Oakdale East Industrial Estate (SSD-37486043) – Stage 2

Thank you for your Major Projects Planning Portal referral dated 25 July 2022, inviting WaterNSW to comment on the Environmental Impact Statement (EIS) for the State Significant Development project at Oakdale East Estate (OEE). The Concept masterplan for the industrial estate provides for the development to be built over 5 stages. It is understood that this application includes development to facilitate the Concept Masterplan, lead-in works, estate-wide infrastructure works, the development of a warehouse and distribution facility in Precinct 3 and extension of the existing approved development in Precinct 1.

Attachment 1 – WaterNSW comments and suggested consent conditions for SSD-37486043 (Stage 2)

Figure 1.2 1% AEP Flow Hydrographs at the WaterNSW Pipeline Corridor

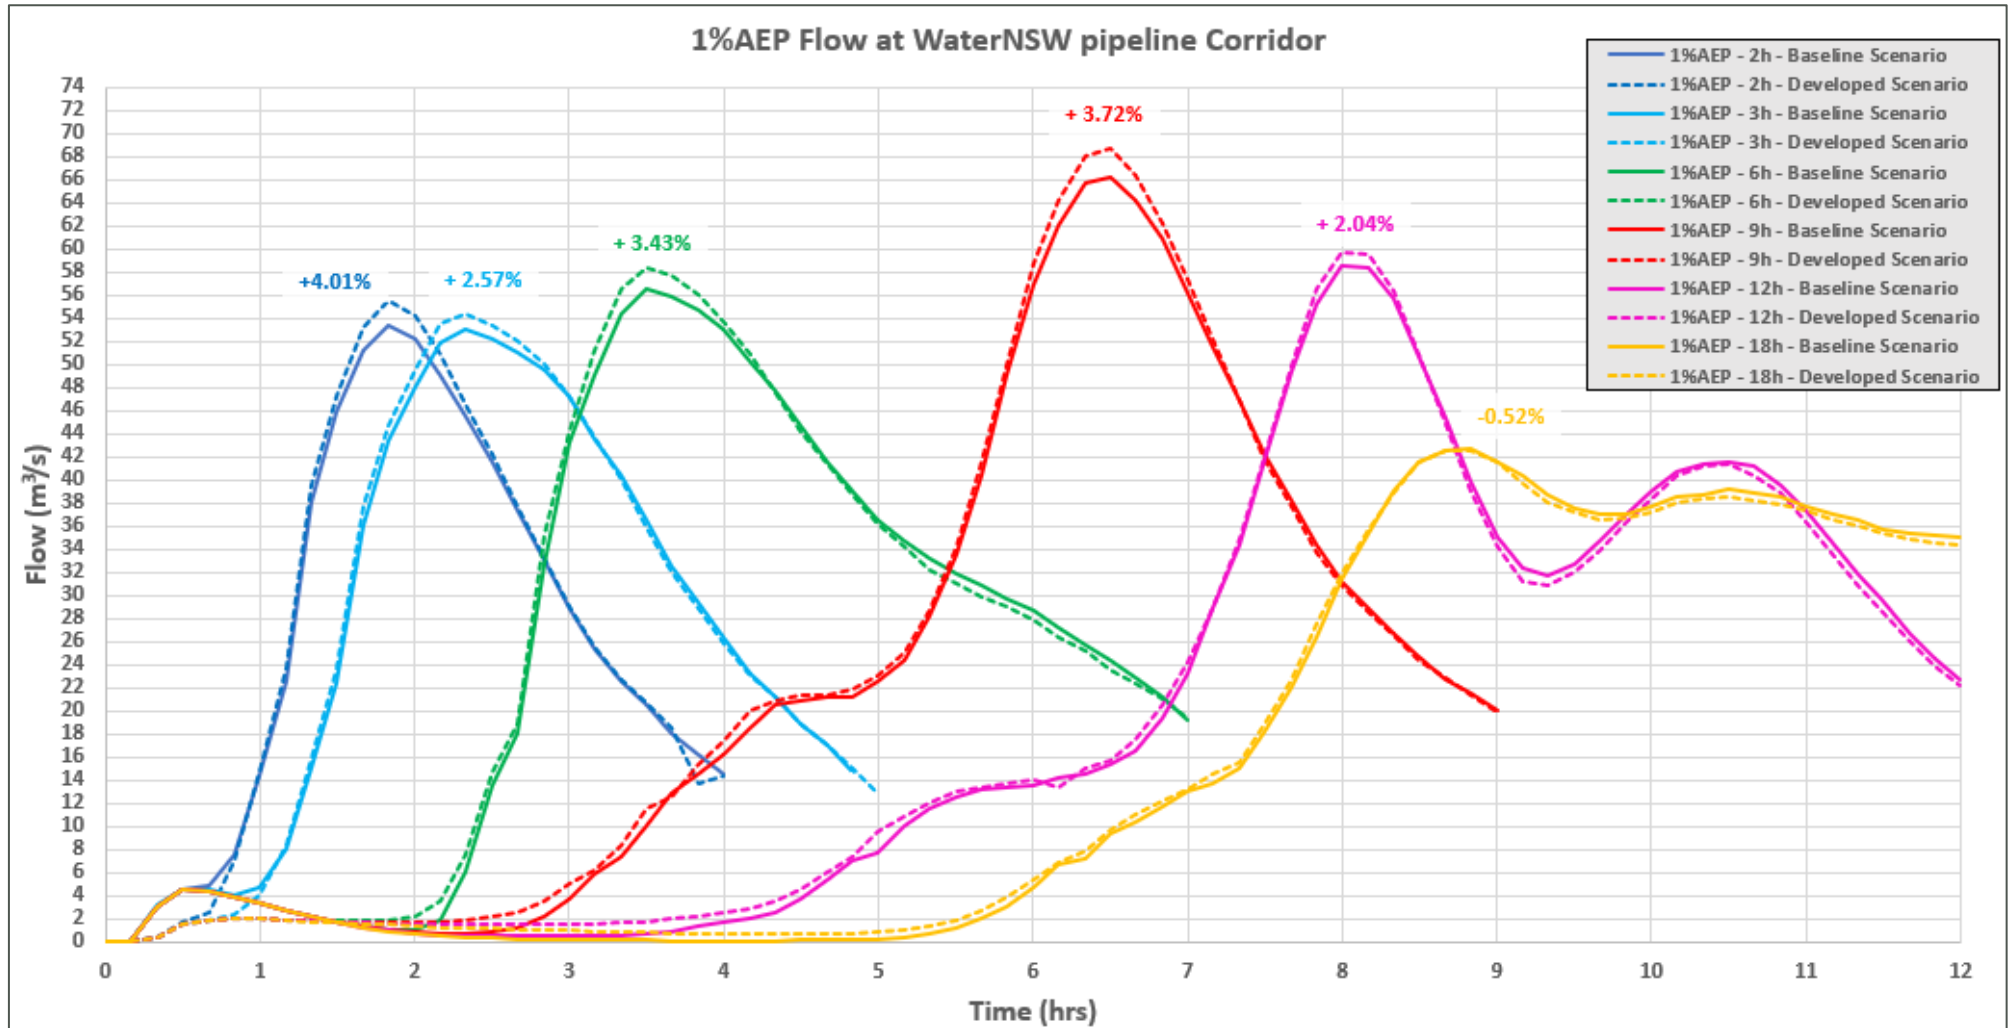
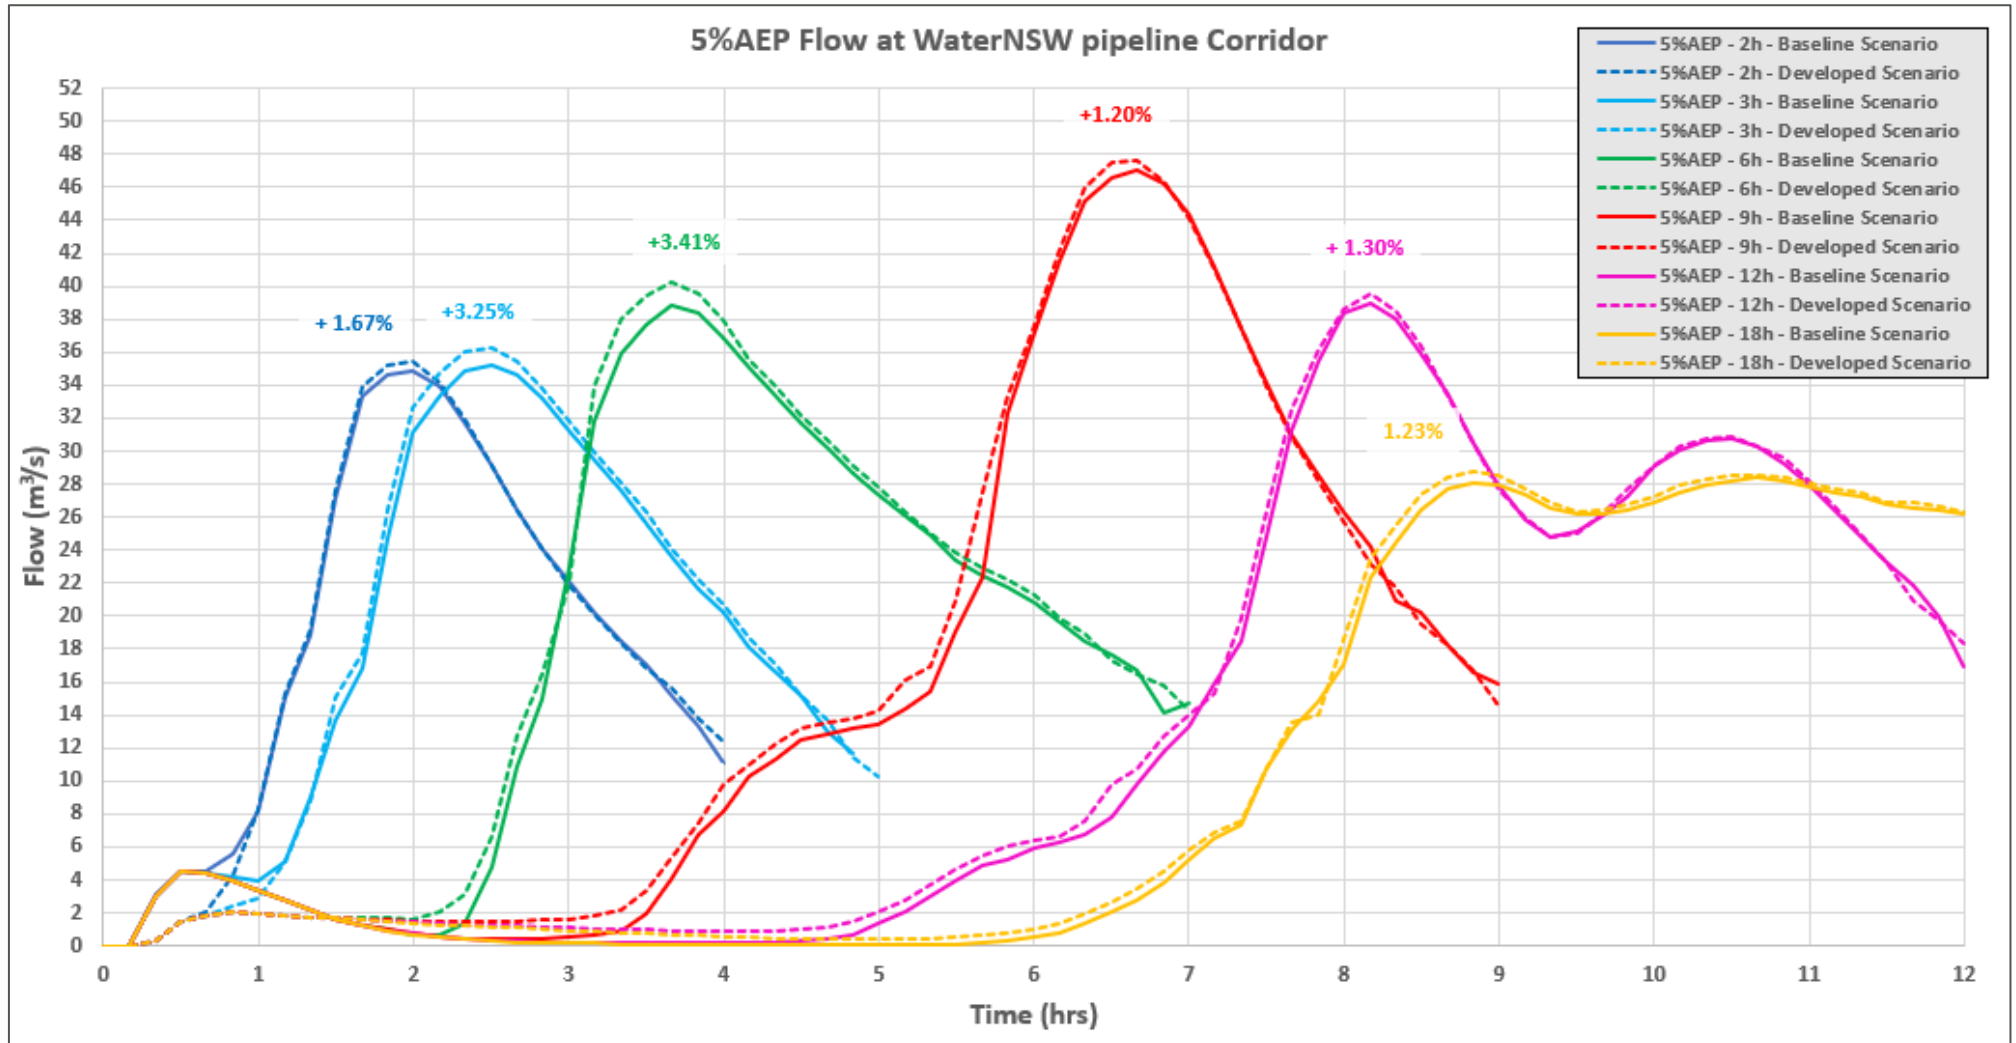
- assessment of downstream impacts
- assessment of impacts on drainage paths into the Warragamba Pipelines corridor, particularly at Reedy Creek, and consideration of Water NSW's Guideline for Development Adjacent to the Upper Canal and Warragamba Pipelines, September 2021
- consideration of downstream impacts on the WaterNSW Pipelines corridor including pre-developed and post-developed surface water flows – WaterNSW requires that post-development flows be equal to or less than the pre-development flows for each storm event up to and including 1% AEP event
- former State Environmental Planning Policy (Infrastructure) 2007 (ISEPP) – Clause 127A, now State Environmental Planning Policy (Transport and Infrastructure) 2021 (ISEPP) – Clause 2.163

- *Final levels and design of the proposal must not result in an increase in overland flow of water into the Pipeline corridor of either quantity, quality or velocity. The development must be designed, operated and maintained to ensure post-development flows do not exceed pre-development flows into and through the Pipelines Corridor.*
